Peartree Hill Solar Farm

Response to Local Impact Report

Application Document Ref: EN010157/APP/8.7

September 2025

Figure 1.2: Land Areas and Cable Routes Plan with Field Numbering System

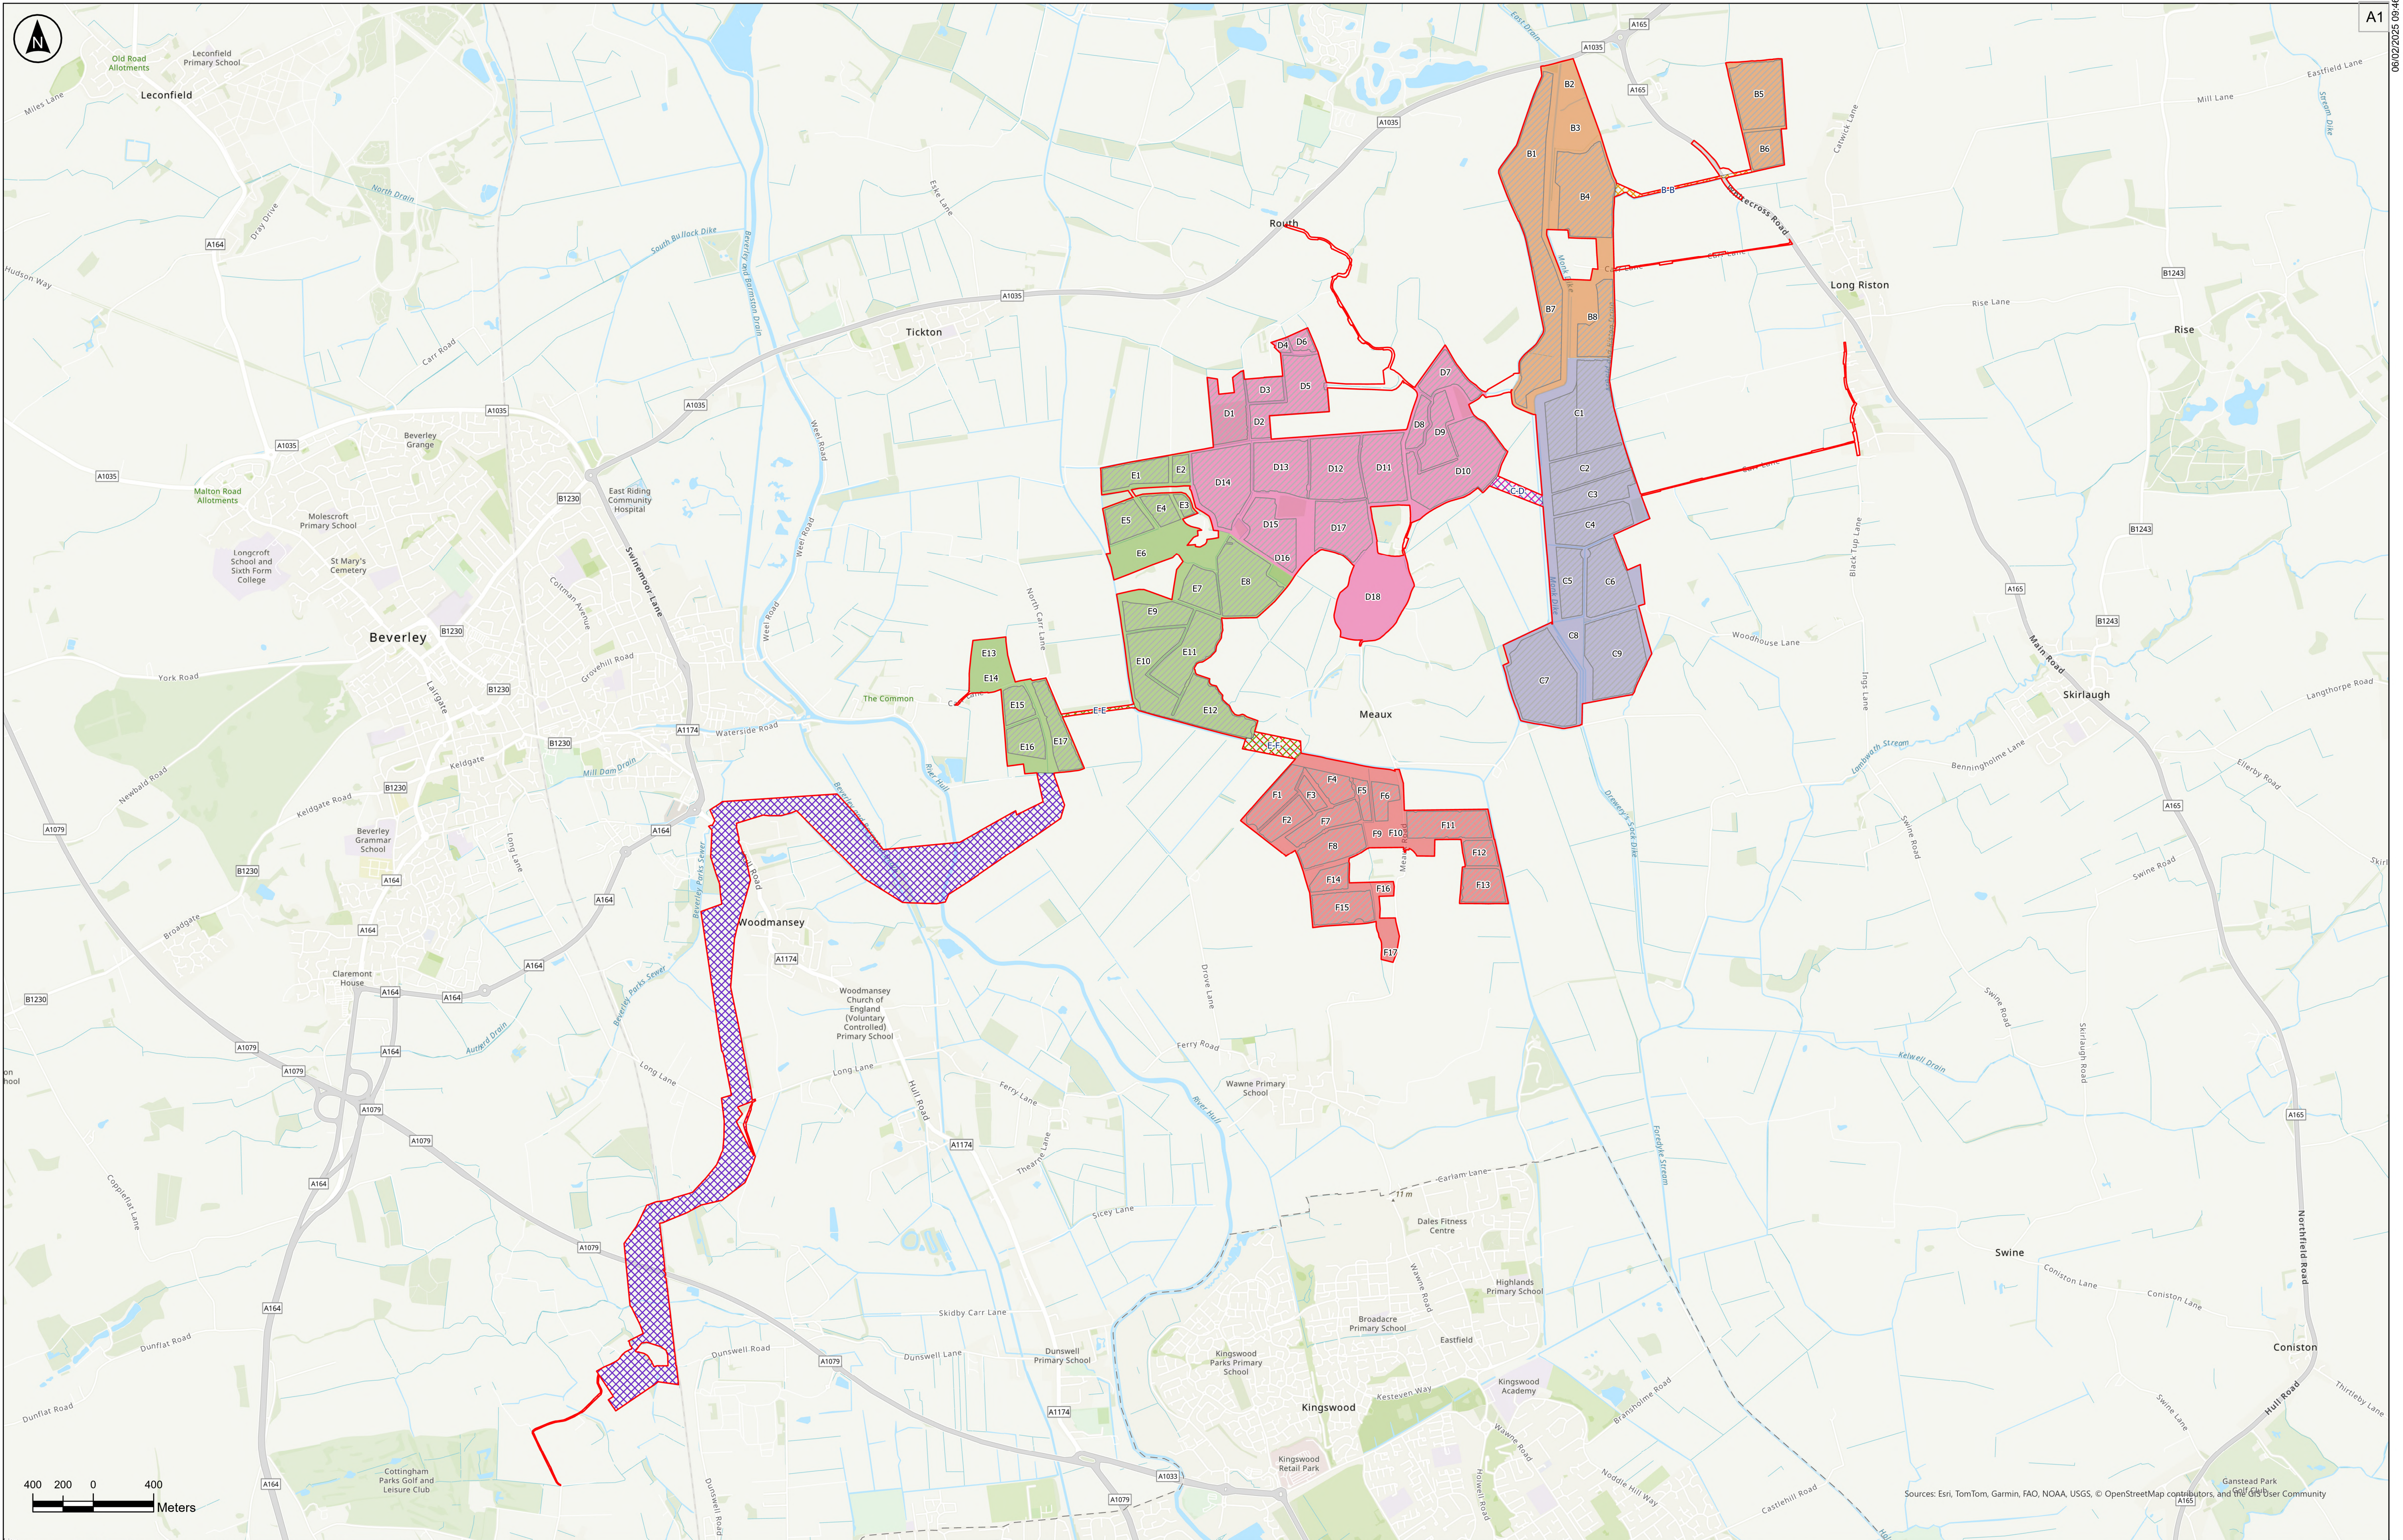
7.127	<p>To provide a successful mitigation at Mitigation Area 11(E6), the land needs to be reasonably open and human activity minimised. There are concerns in relation to the extent of enclosure of Mitigation Area 11 (E6) and the introduction of permissive access paths around the site boundaries. There are solar panels to be installed to the immediate north and further enclosure is likely to occur to the west should the Carr Farm Solar Scheme 22/03648/STPLFE be implemented following its recent allowed appeal decision. Views are secured to the south of the site due to the presence of the Scheduled Monument (Meaux duck decoy), however, existing mature trees on this site slightly impact the mitigation area. The site and proposed scrapes also straddle flood zones 2 so there is concern in relation to the deliverability of wet grassland in this area.</p>	<p>The Applicant acknowledges EYRC's concerns regarding the permissive paths within Mitigation Area 11 (E6). The Applicant is giving consideration to ways of addressing this issue, such as re-routing the path outside Mitigation Area 11 (E6). The Outline LEMP [EN010157/APP/7.5 Revision 4] and ES Volume 3, Figure 3.4: Indicative Environmental Masterplan [APP-058] will be updated to reflect any changes as necessary and submitted at subsequent deadlines.</p> <p>Section 3.2 of the Outline LEMP [EN010157/APP/7.5 Revision 4] was updated with further information at Deadline 1 regarding the viability of the proposed SPA/Ramsar mitigation areas.</p>

<p>7.128</p>	<p>Mitigation Area 13 (E13 and E14) is well placed to the west of the development and connects to the Carr Farm Solar proposed SPA/Ramsar mitigation area. However, it is not dependent on that proposal in order to deliver an appropriate mitigation area. Existing hedgerows to the south mitigate the impact of introduction of solar panels to the south. The position between the Humber Estuary and Swinemoor Common Local Wildlife Site (known FLL) is optimal. The site lies within Flood zone 1, however, EA surface water flood maps indicate that some areas of the site are vulnerable to surface water flooding and the likelihood of scrapes holding water is increased. The existing use of this area by roosting curlew on passage indicates its suitability for targeted enhancements and that existing hedgerows do not pose a constraint to use by this sensitive species.</p>	<p>The Applicant acknowledges ERYC's Nature Conservation Officer's comment.</p> <p>Section 3.2 of the Outline LEMP [EN010157/APP/7.5 Revision 4] was updated at Deadline 1 with further information regarding the viability of the proposed SPA/Ramsar mitigation areas.</p>

<p>7.129</p>	<p>Similarly to Mitigation Area 11, there are concerns about the introduction of recreational activities around the Mitigation Area 9. This has the potential to displace passage and wintering birds compromising the success of the mitigation area. The proposal states that the mitigation areas will be managed for 30 years. SPA/Ramsar Mitigation Areas must be managed for the lifetime of the development.</p>	<p>The Applicant acknowledges Natural England's concerns regarding the permissive paths within Mitigation Area 11. The Applicant is giving consideration to ways of addressing this issue, such as re-routing the path, use of signage in appropriate locations instructing dog walkers to keep their dogs on a lead, fencing and appropriate screening. The Outline LEMP [EN010157/APP/7.5 Revision 4] and ES Volume 3, Figure 3.4: Indicative Environmental Masterplan [APP-058] will be updated to reflect any</p>

<p>changes as necessary and submitted at subsequent deadlines.</p> <p>Section 1.1.15 of Outline LEMP [EN010157/APP/7.5 Revision 4] states the Landscape and Ecological Management Plan will be reviewed after 30 years to ensure it is fit for purpose for the remaining 10 years of the Proposed Development operation. It is acknowledged that any mitigation will need to be managed for the operational life of the Proposed Development as secured in the Outline LEMP [EN010157/APP/7.5 Revision 4].</p>

Figure 14.2: Transport Routing and the Existing Highway Network

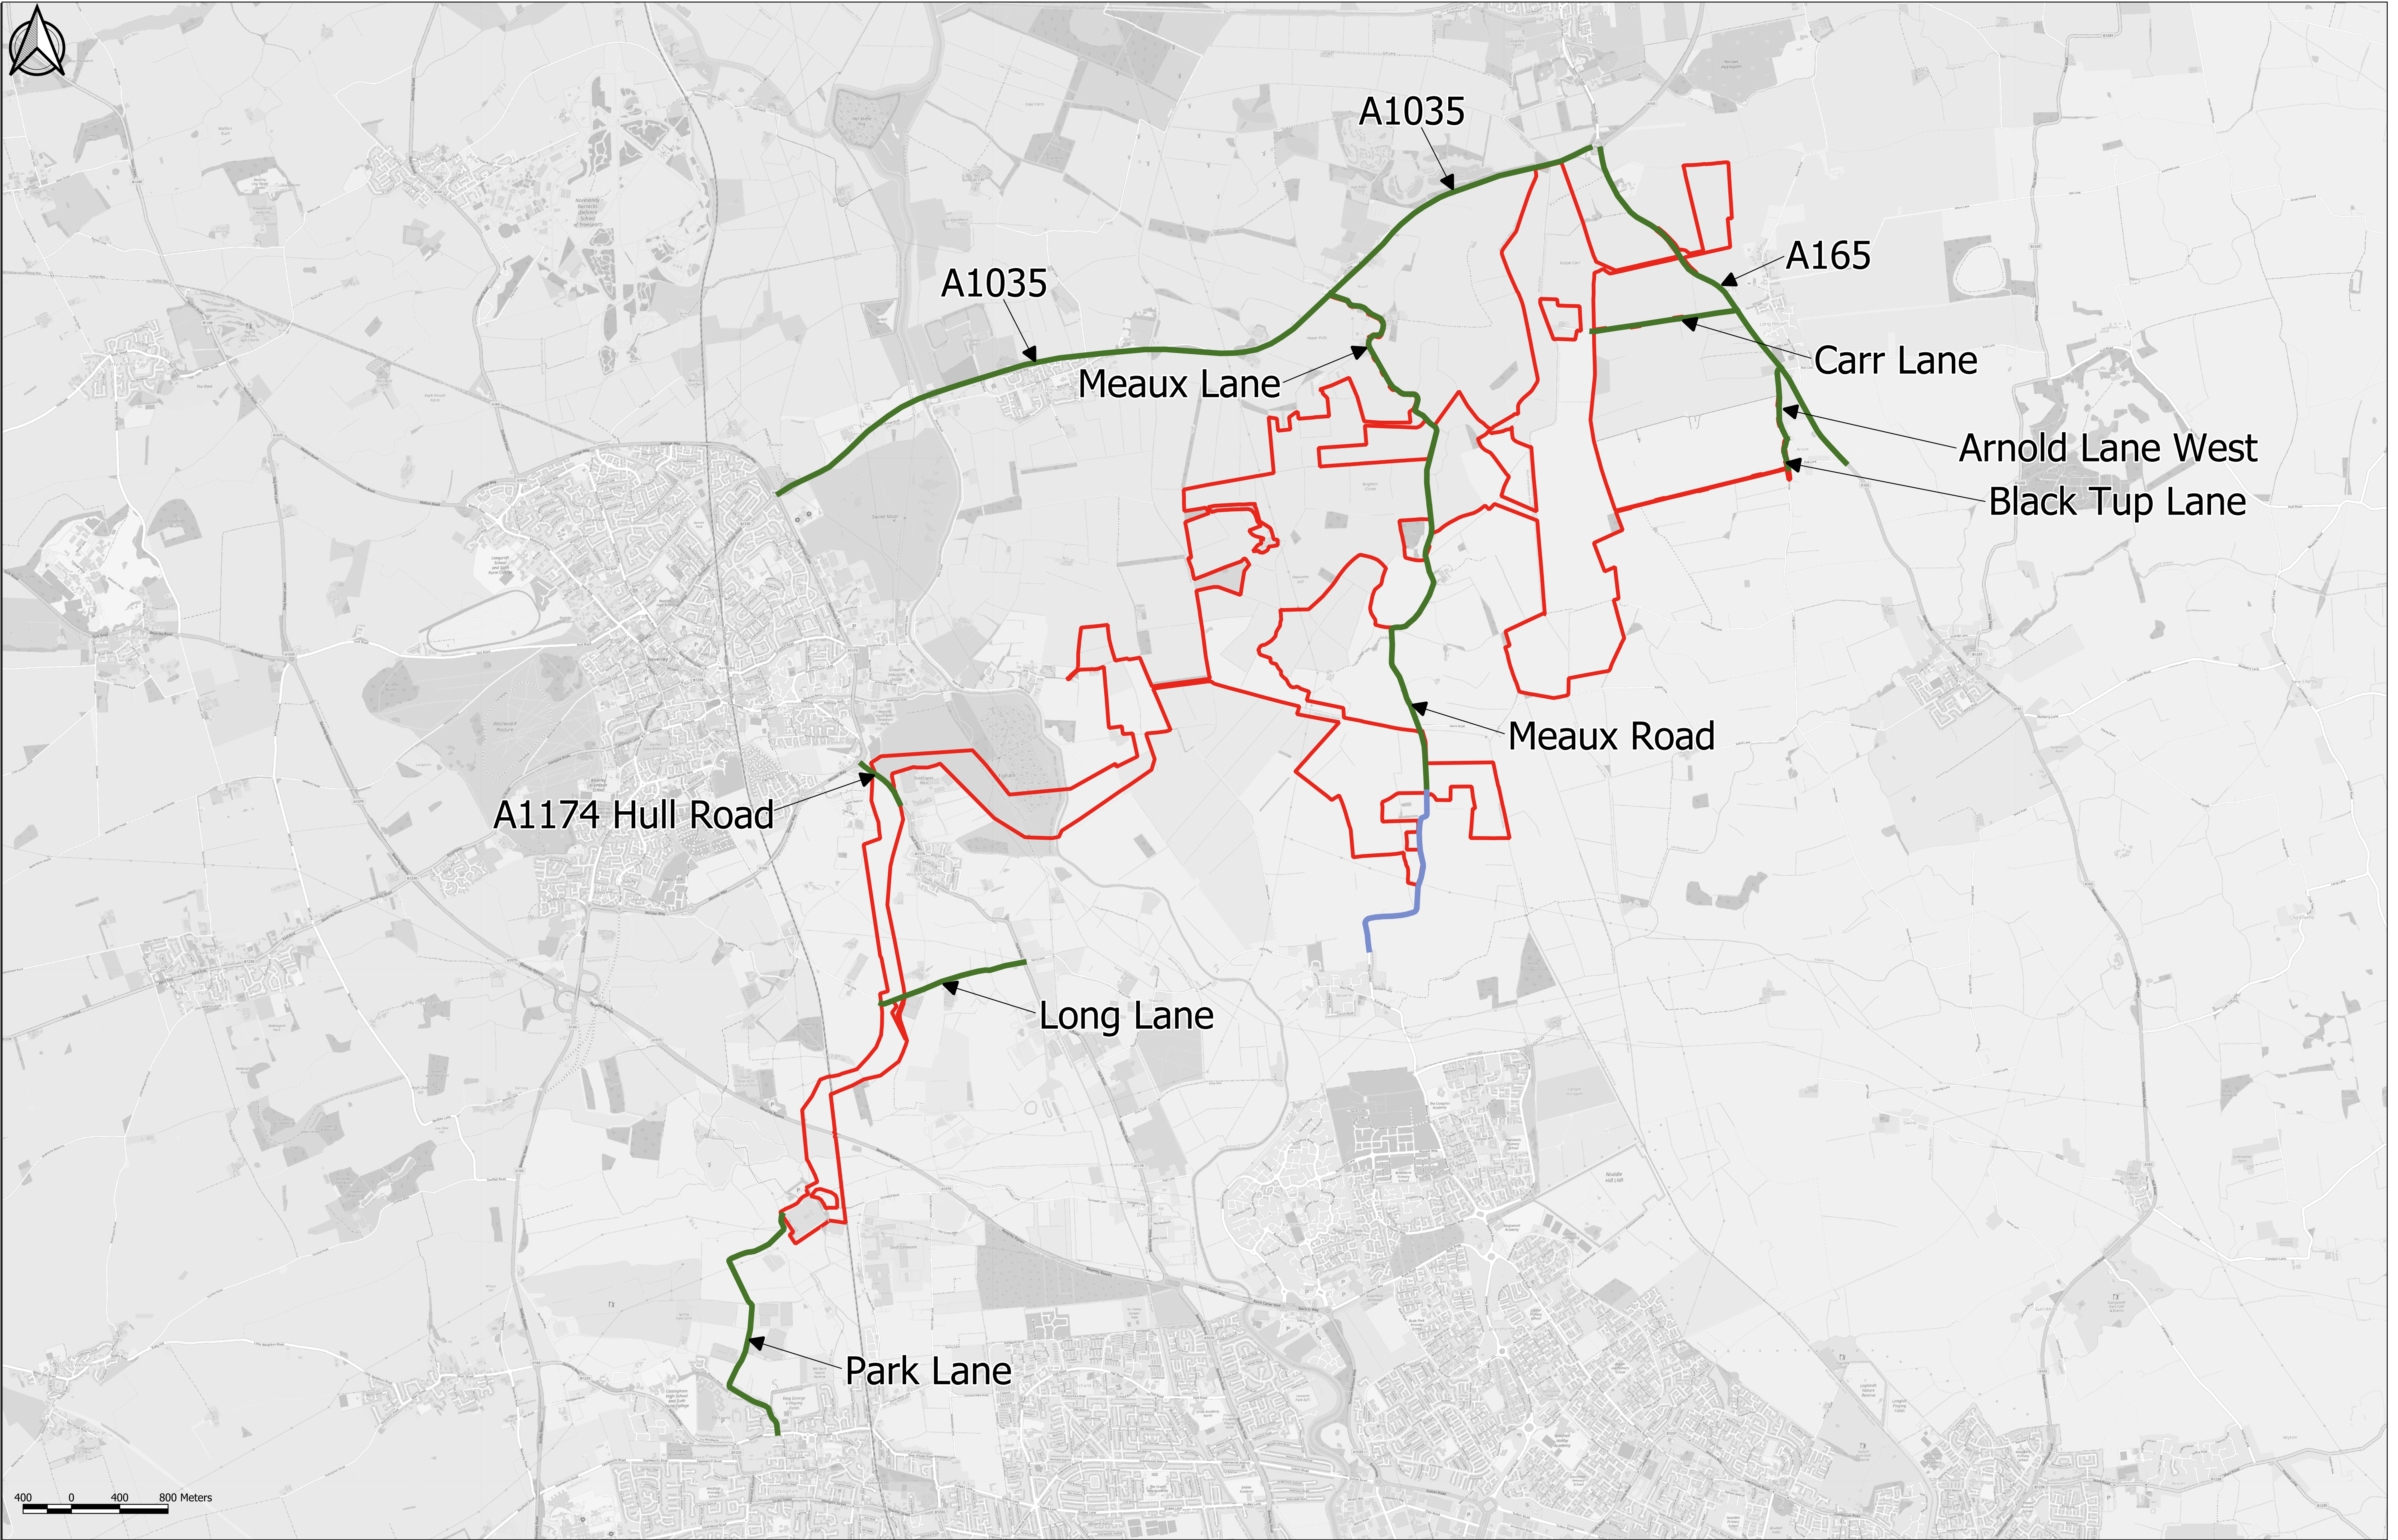
7.74	<p>Concerns are had by the ERYC Highway Development Management Officer with regard to the proposed use of Park Lane, Cottingham as the access route. The oCTMP states that it would only be required briefly and would only require a small number of HGVs and LGVs. However, Park Lane is split into two main sections; the first part is a highly residential estate road whilst the second part is of single-track width and a well-used public right of way by both cyclists and walkers. The access from Northgate is also very constrained both in terms of tight radii and limited visibility. Additionally, ERYC do receive complaints on the narrow nature of Northgate when local residents are parked which acts as a throttle in places restricting the width to one way movement. It should be noted that there is a live planning application from National Grid for additional substations which would be required to provide an access from a layby off the A1079 which would be a much more suitable access for any additional vehicles to Creyke Beck substation. ERYC Highway Engineers have already granted technical approval for these works. Therefore, given the highway situation on Park Lane and potential for a viable alternative, ERYC consider that the use of Park Lane could have significant impact even if only used for a short period and would therefore object to the use of this access to serve the development.</p>	<p>The Applicant cannot commit to the use of the potential new National Grid access off the A1079 at this point given there is no consent in place for its delivery. In addition, the Applicant does not have the requisite land rights in place, nor does it foresee them being able to be voluntarily agreed within a reasonable timeframe that would reflect the necessary change requirements during Examination. The Applicant acknowledges EYRC's comments regarding the proposed access but stresses that no significant impacts have been identified in ES Volume 2, Chapter 14: Transport and Access [EN010157/APP/6.2 Revision 2] and that the Applicant has committed to further controls around the use of Park Lane within the Outline Construction Traffic Management Plan (CTMP) [REP1-060], notably no construction vehicles using Northgate and/or Harland Way during school drop-off and pick-up times.</p>

7.104	Routing of HGVs via Park Lane, Cottingham to the substation has previously been identified as unacceptable to ERYC.	See response to 7.74 above.
7.105	Section five of the oCTMP covers the larger movements and identifies the swept paths for a typical 16.5m articulated vehicle and are acceptable pending additional plans as outlined in the Transport Assessment section. The oCTMP identifies that a specialist haulier would be required for the AILs and that a full route survey would be required. This is agreed and should be	See response to 7.89 above.
